CITY OF ALBUQUERQUE

June 9, 2017

Re: Town Houses For Buchanan
4662 12TH Street NW
Traffic Circulation Layout
Engineer's/Architect's Stamp **06-15-17 (F14-D074)**

Based upon the information provided in your submittal received 06-01-17, the above referenced plan cannot be approved for Building Permit until the following comments are addressed:

**1 TRAFFIC CONTROL LAYOUT**  
Scale: 1" = 20'-0"

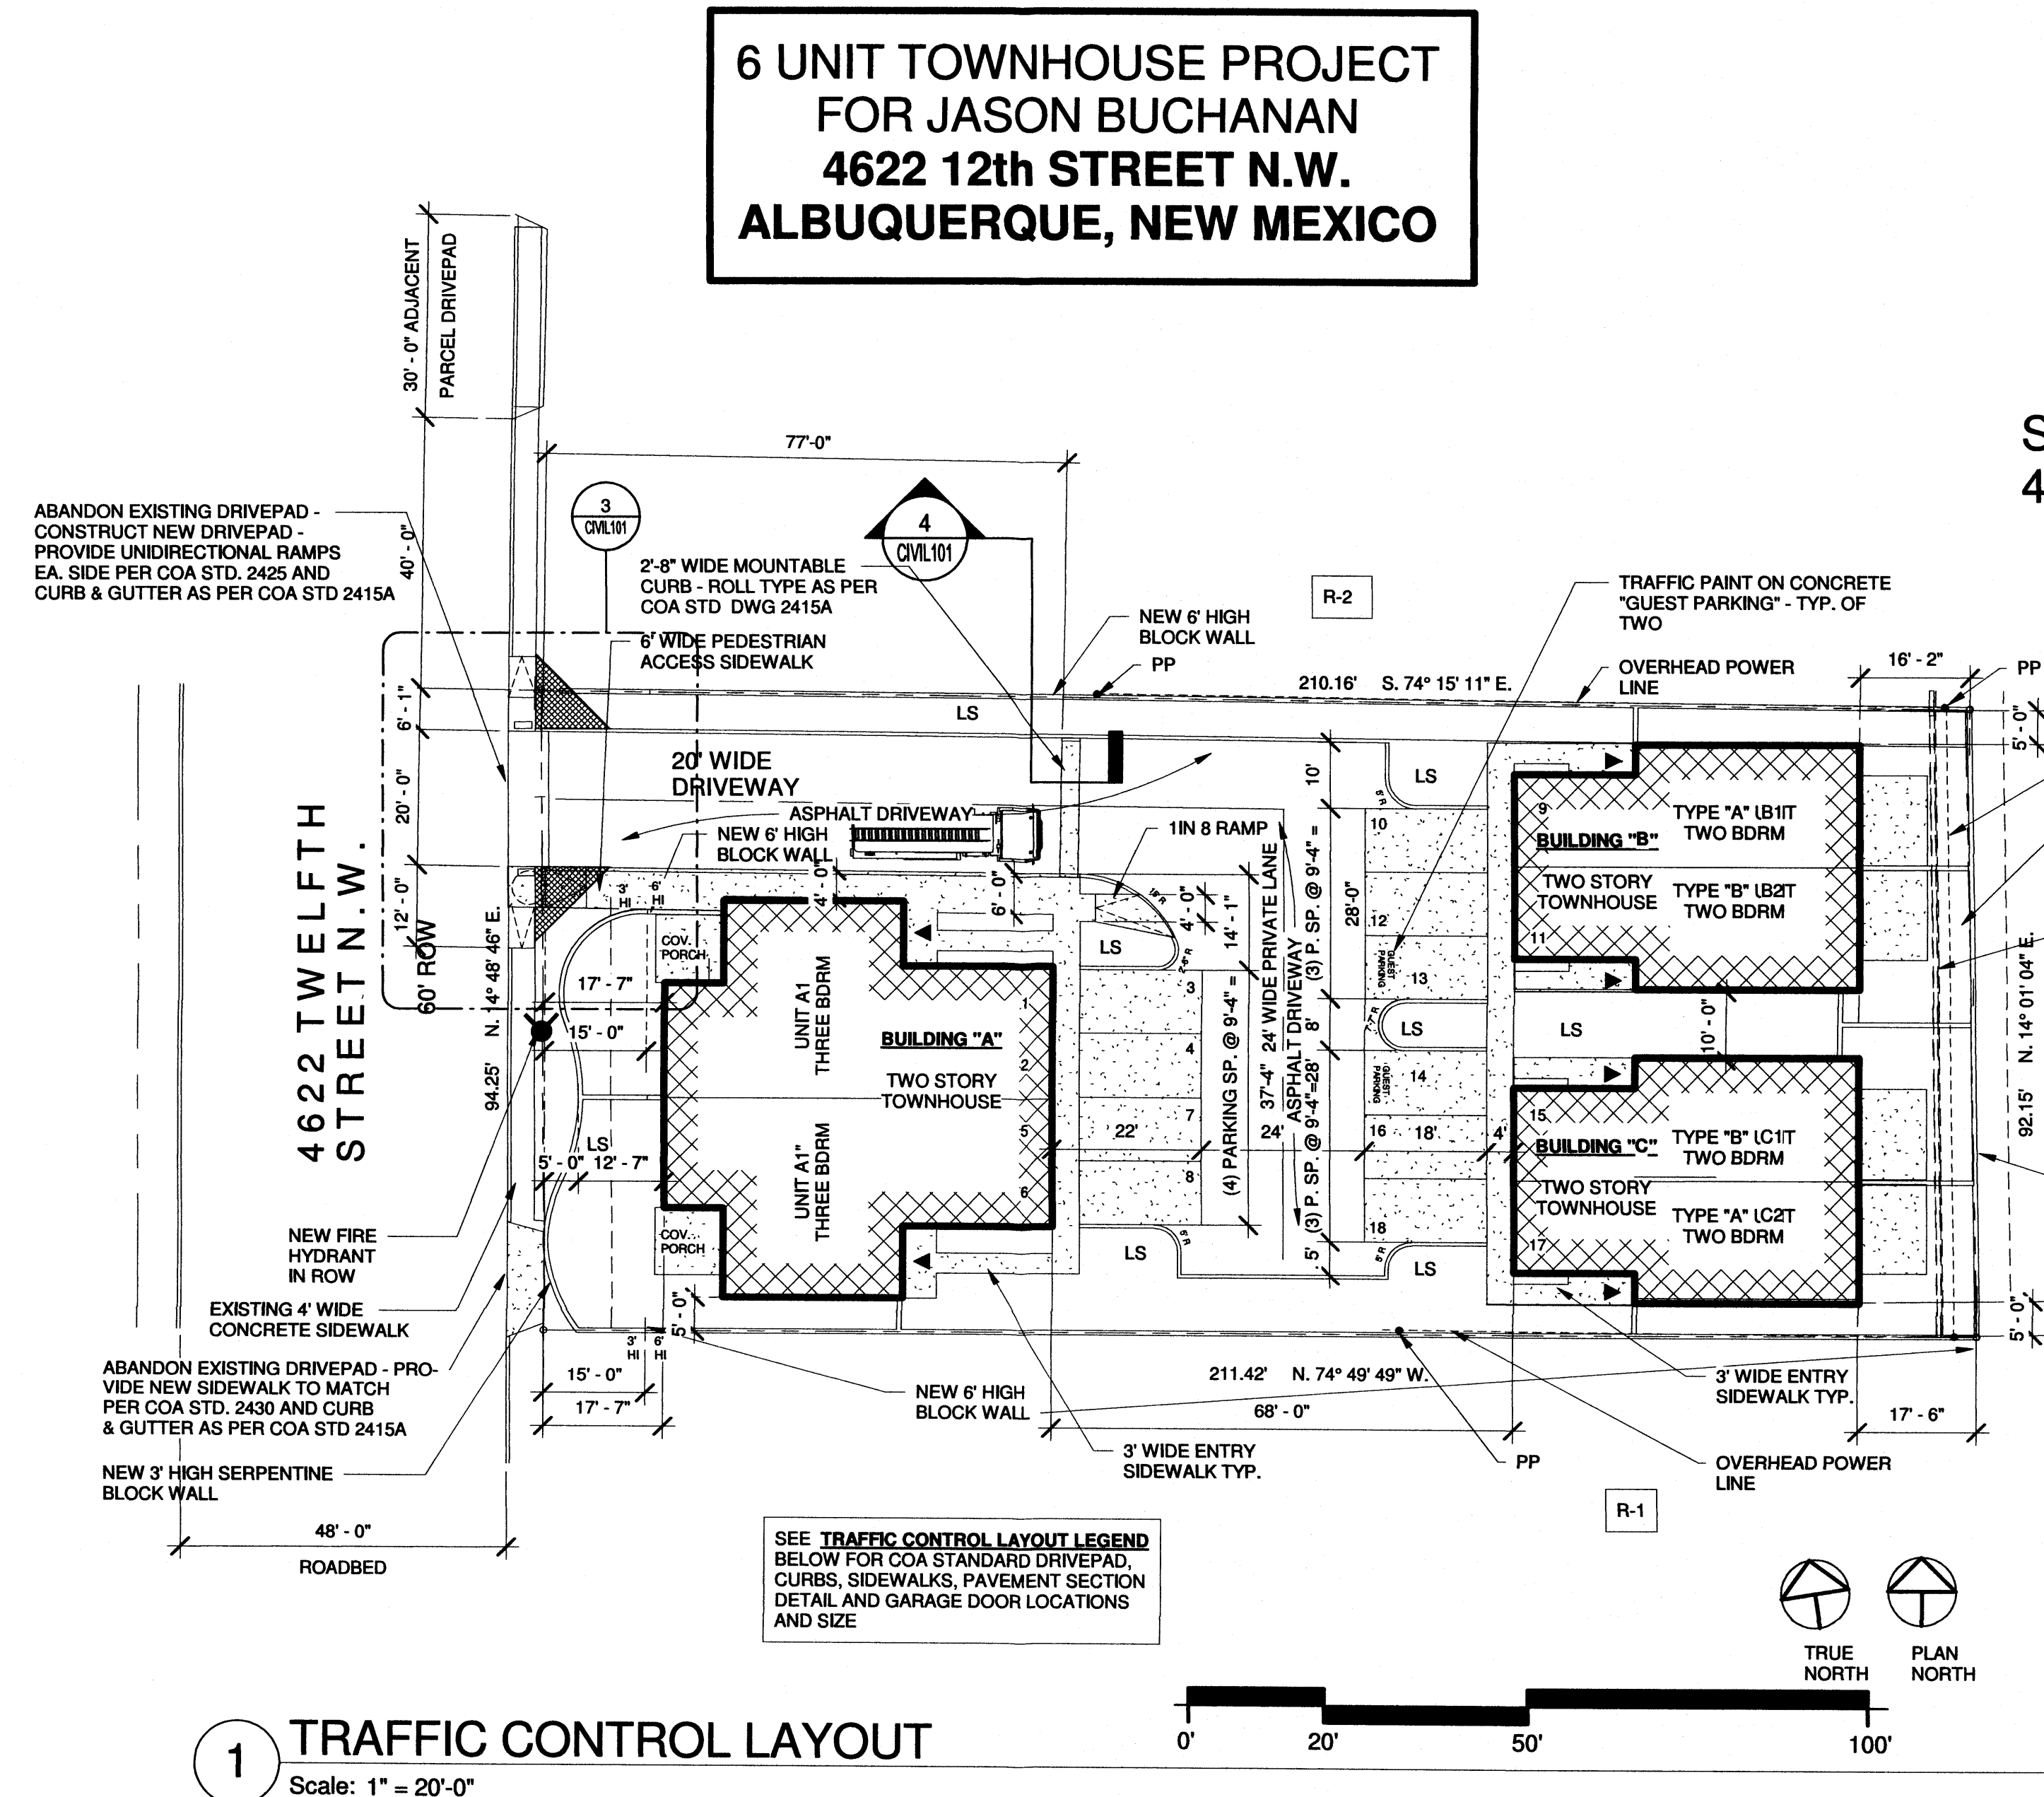
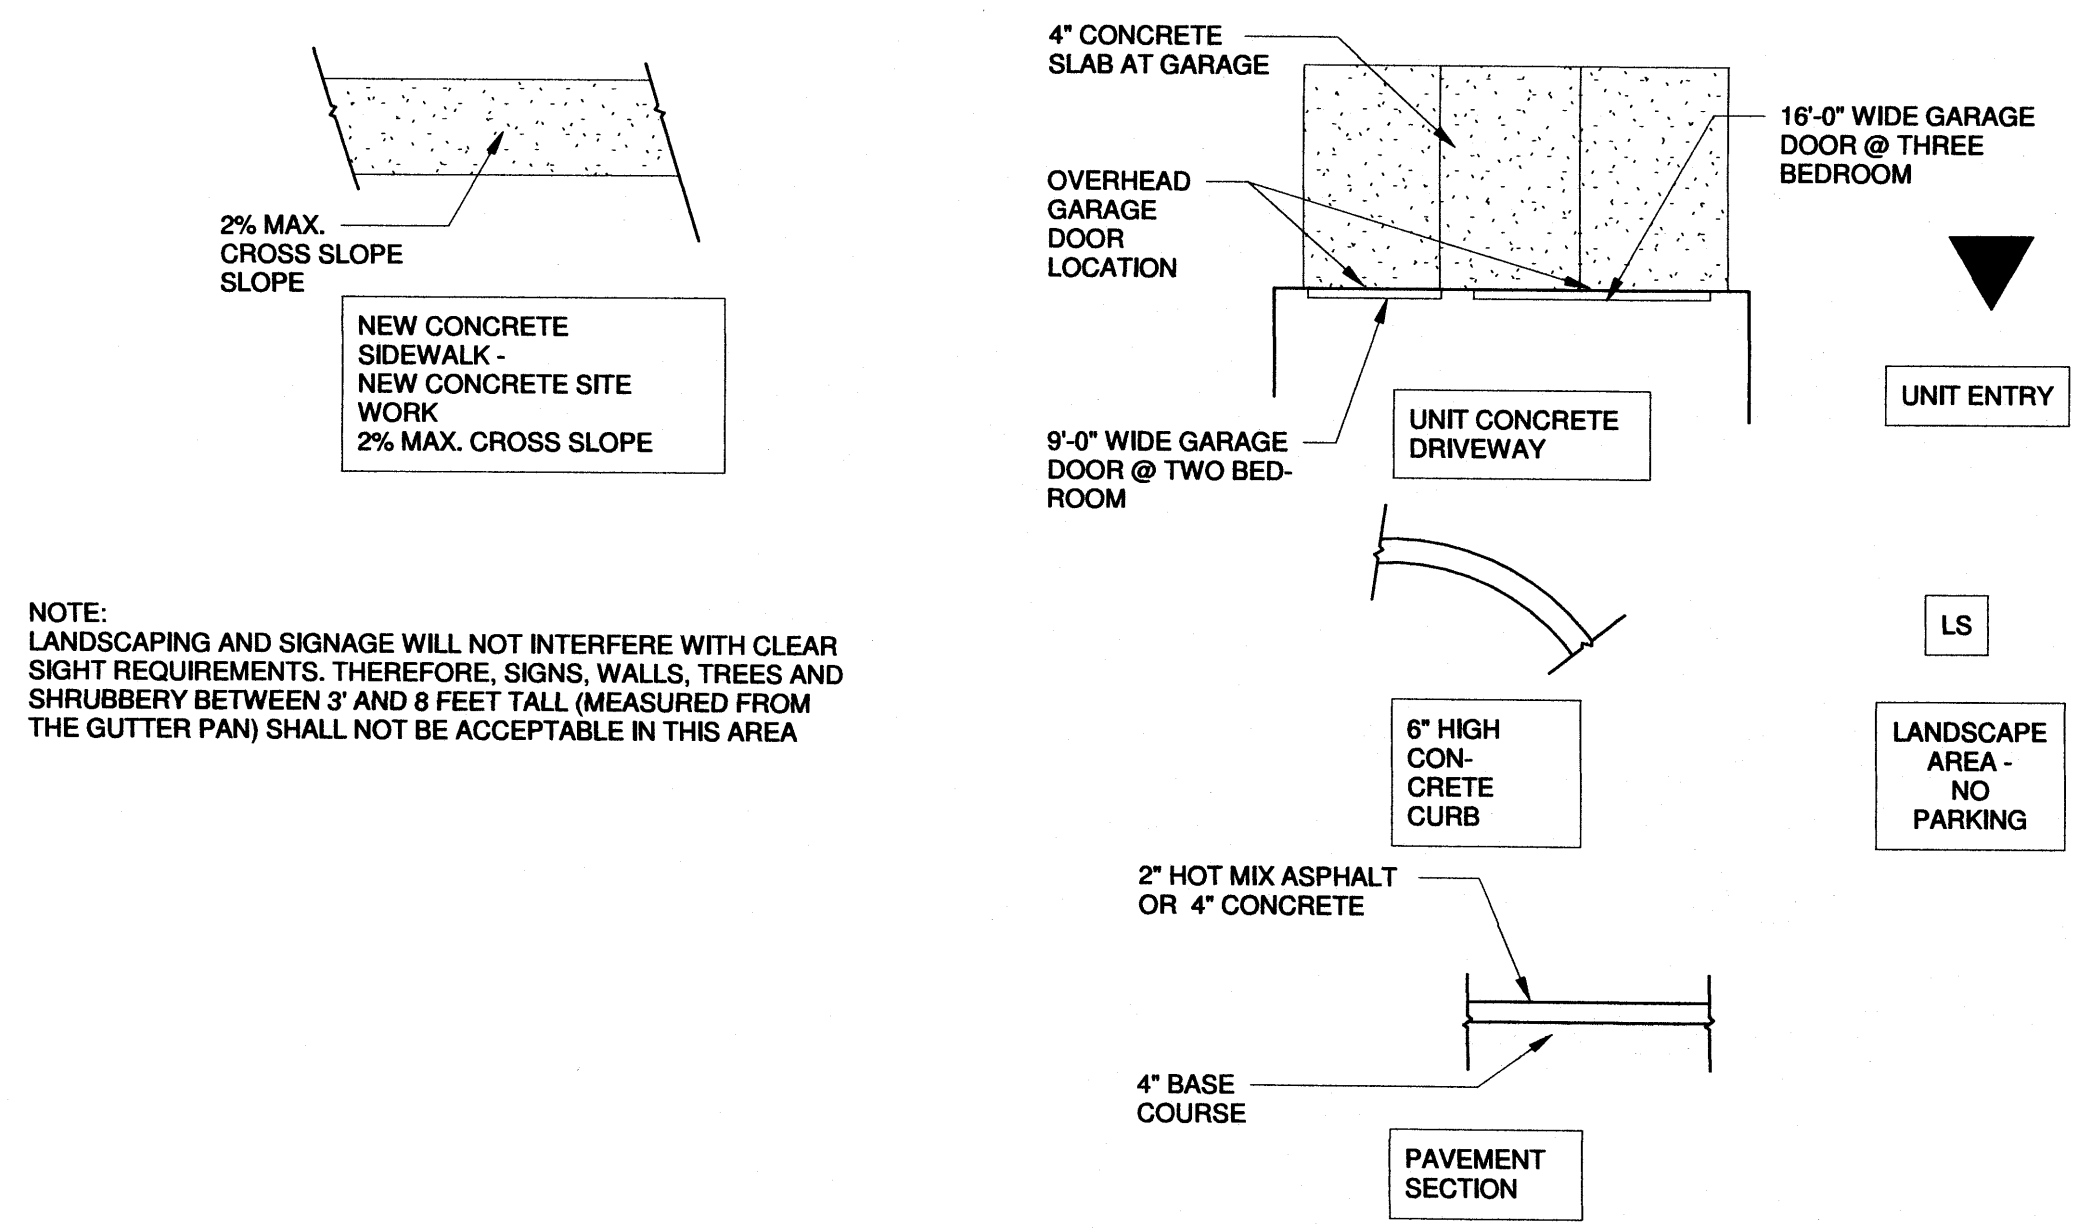
1. 24 feet is required for two way traffic.
2. Please extend the median islands to the end of the parking space.
